Albuquerque
Metropolitan
Arroyo
Flood
Control
Authority

February 4, 2011

Re: Journal Center Office Building, Tracts A2 & A3, ZAP D-17
Preliminary Plan Review

PRELIMINARY GRADING AND DRAINAGE PLAN

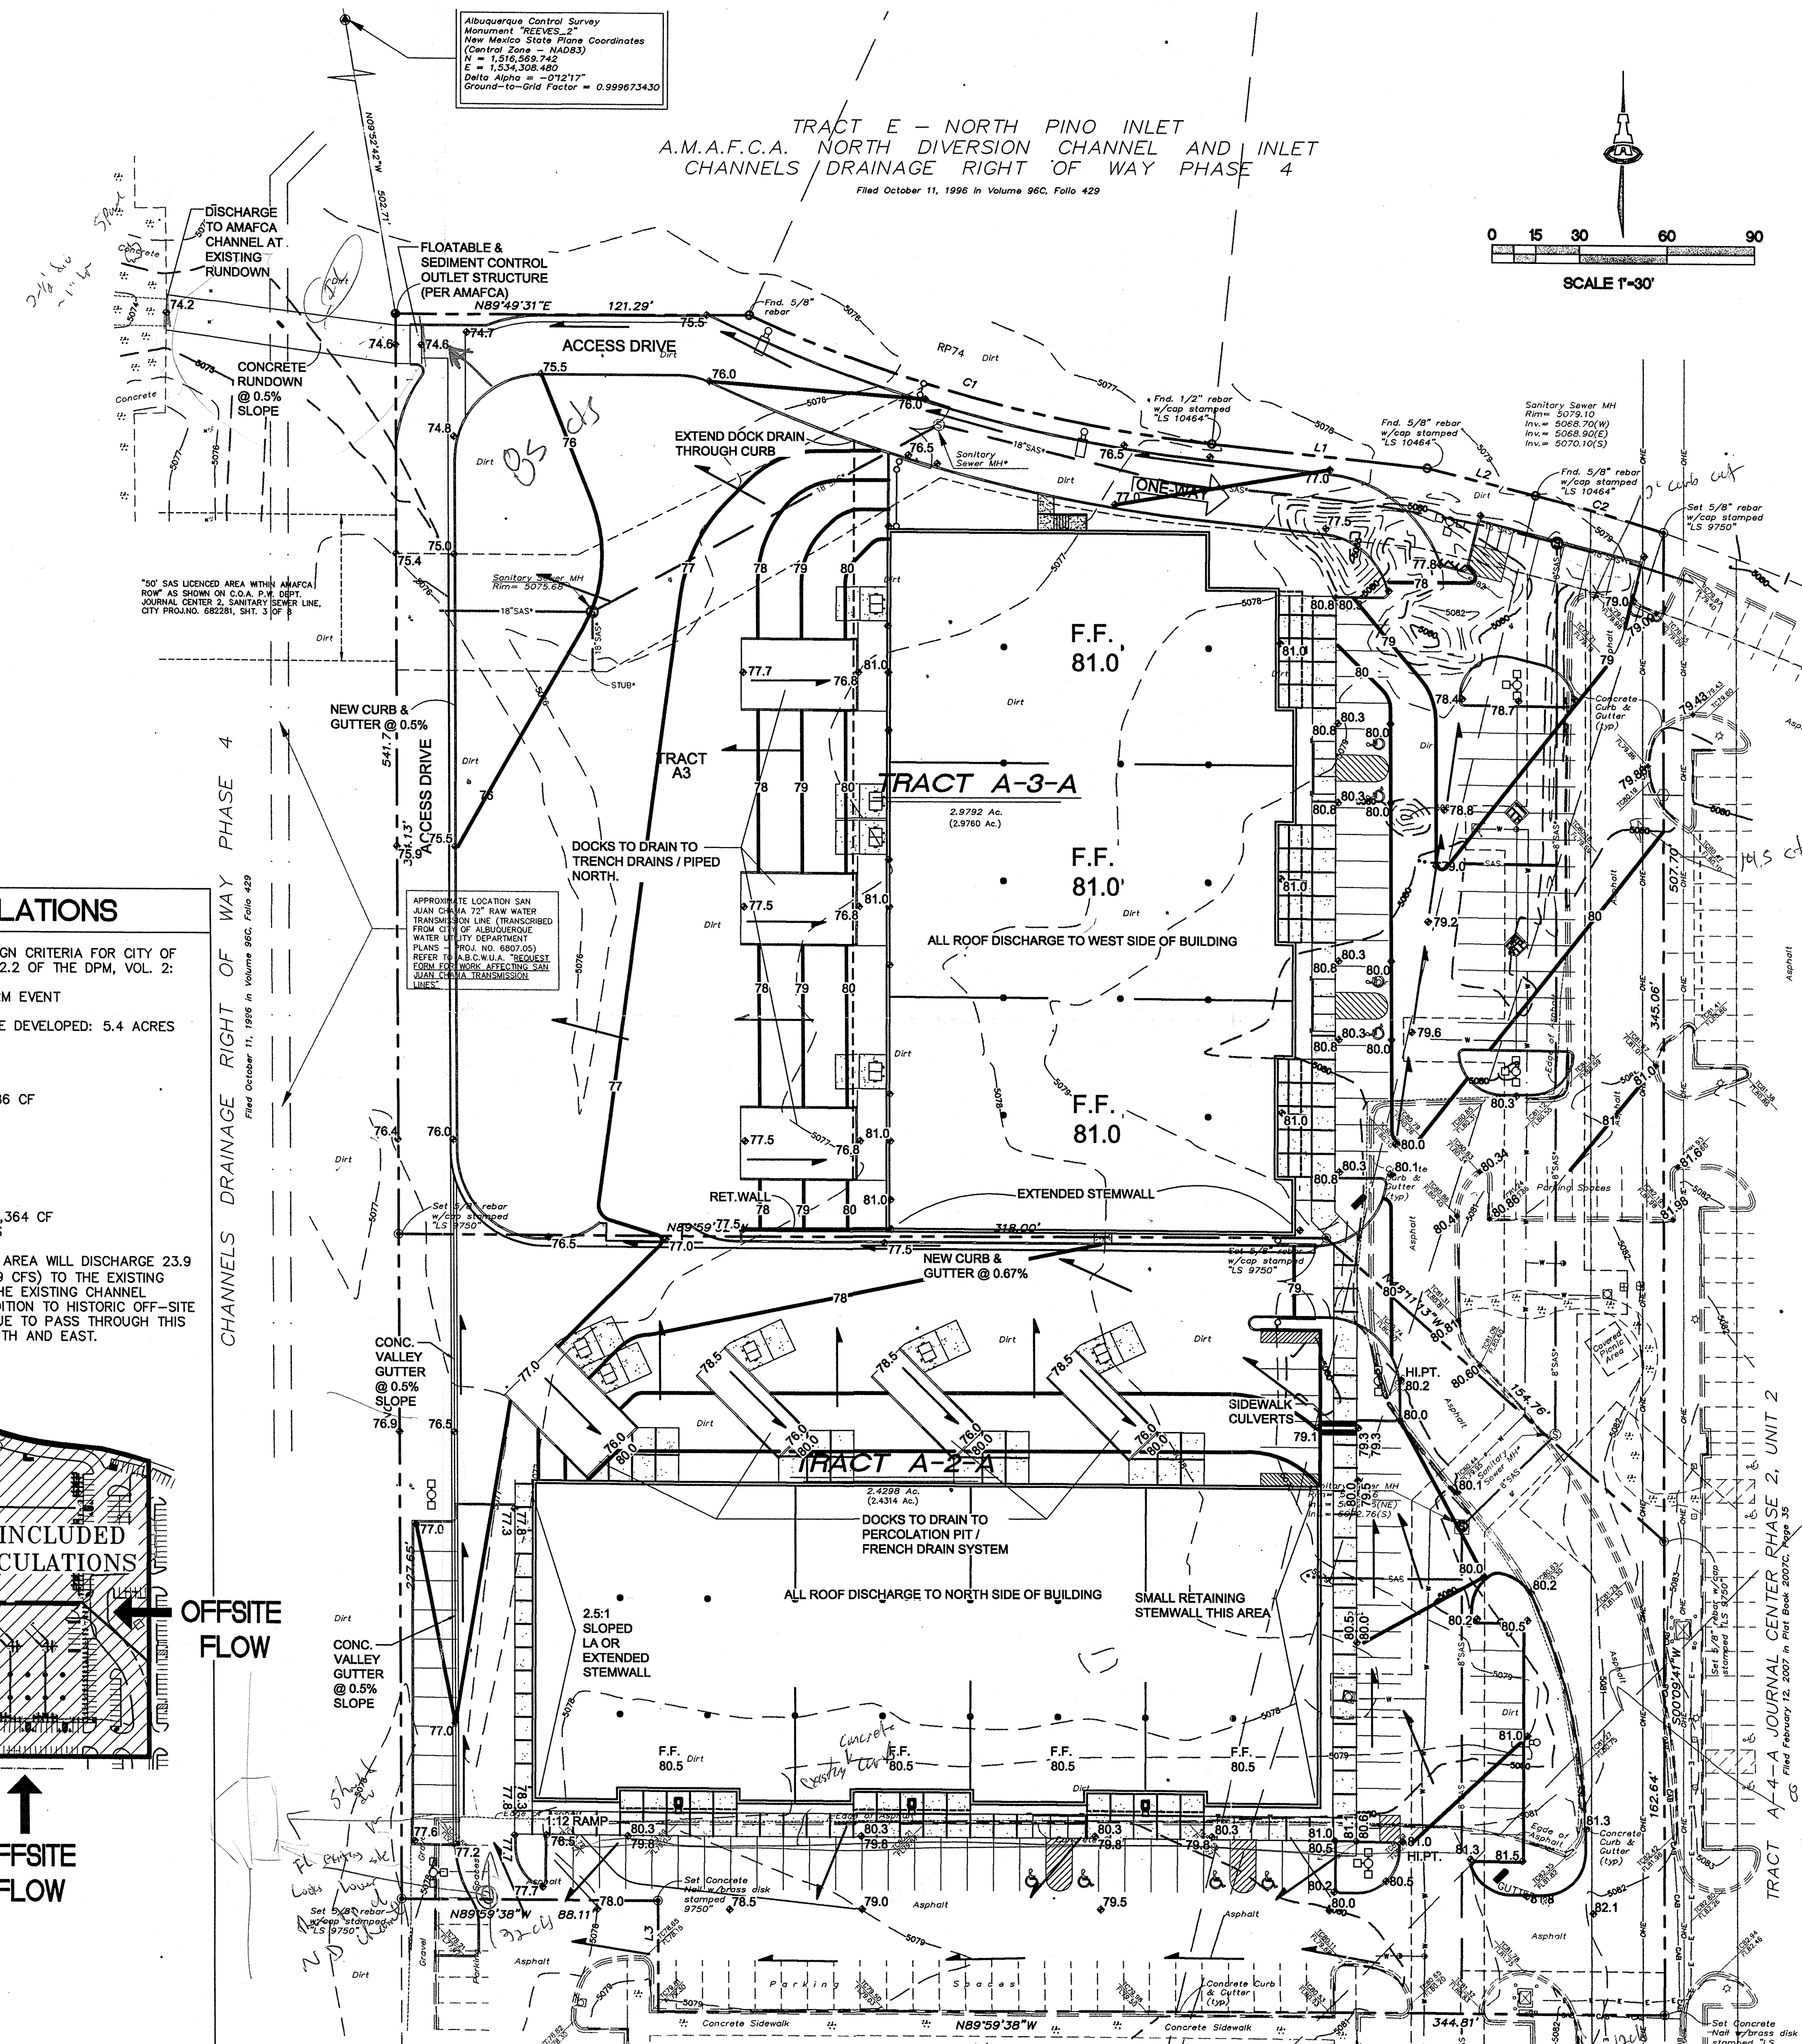
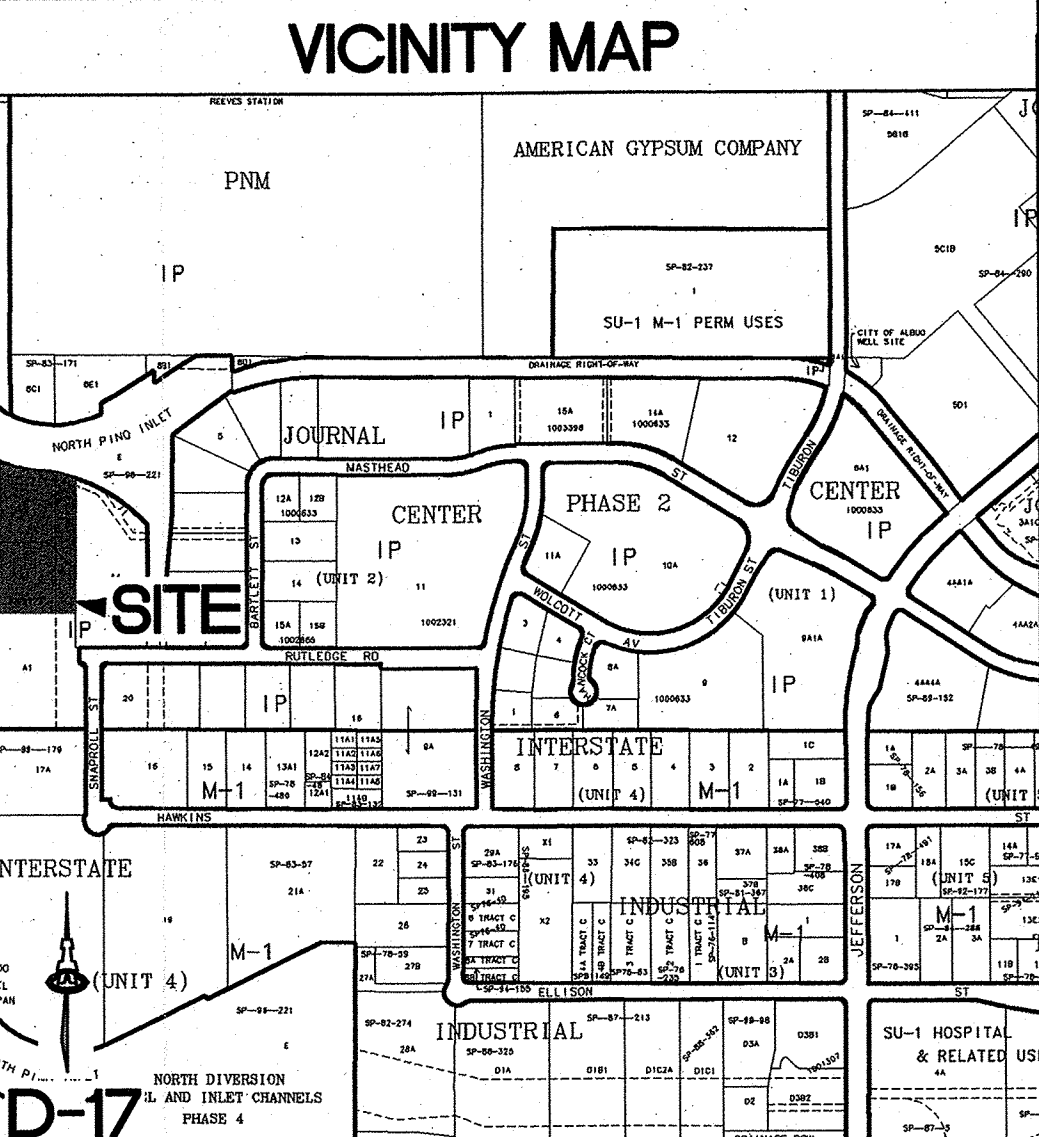
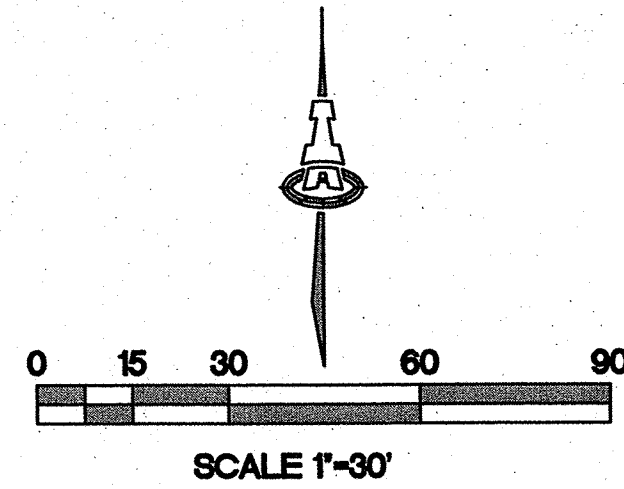
I reviewed the plan with respect to the water quality pond and outfall connection to the North Diversion Channel (NDC). Attached is the detail layout sheet with my mark-ups. I am not ready to approve the preliminary layout; I will need to see the site plan to determine the site drainage pattern. On the detail sheet, it appears that only the loading dock area and the internal access road drain to the water quality pond. The intent of the water quality treatment is to take the first flush rainfall over the entire site through the pond.

I discussed the status of the Essayons Boulevard project with the AMAFCA Executive Engineer, Jerry Lovato. The project is a few years out and has not been approved by the AMAFCA Board of Directors or the U.S. Army Corps of Engineers. Therefore, we will require a concrete rundown connection to the existing NDC rundown structure as you have shown on the plan. We will also require it to extend to the south to capture the flow in the existing side inlet channel.
